State Significant Development 14\_6387

# RESPONSE TO SUBMISSIONS

Mixed use development comprising 3 buildings containing residential apartments above podium level commercial uses (SSD 14\_6387)

**September 2014**

DRAWING TITLE  
**WINTER SOLAR STUDIES**

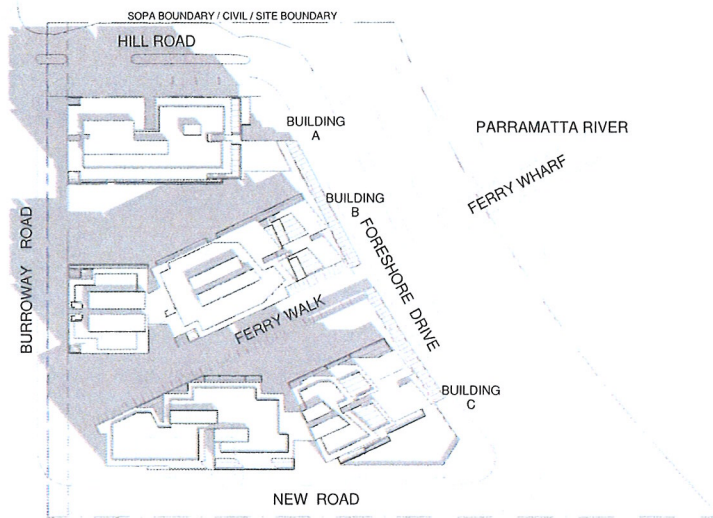
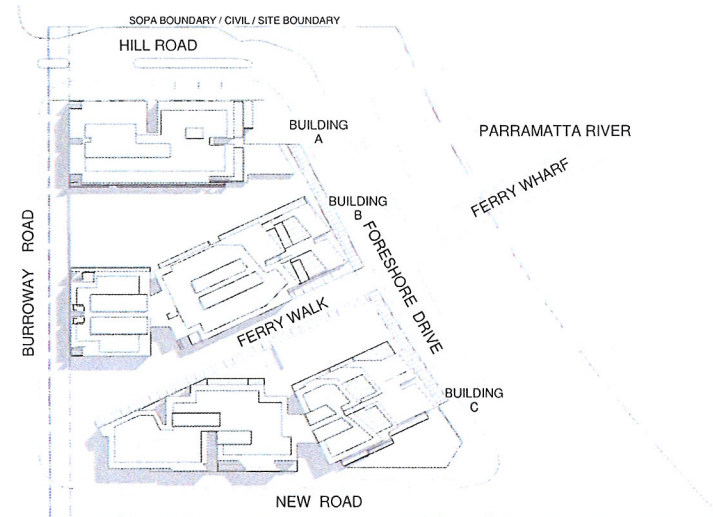
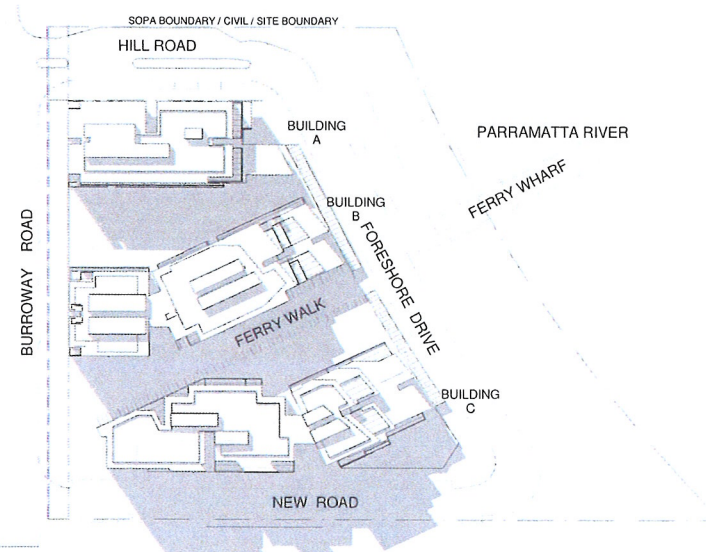
Identify which units will receive a minimum of three hours of solar access during mid-winter and demonstrate that adequate amenity is provided with consideration of the standards in the Sydney Olympic Park Master Plan 2030 and the Residential Flat Design Code

The amended architectural package illustrates those apartments which receive both two and three hours of solar access to living room windows and private open spaces in mid winter and demonstrates that the proposed development exceeds the requirement under the Residential Flat Design Code for 2 hours of solar access to 70% of apartments in dense urban areas. The amended development has been specifically modified by shifting the orientation of some facades and reconfiguring internal layouts to maximise the solar access which can be achieved.
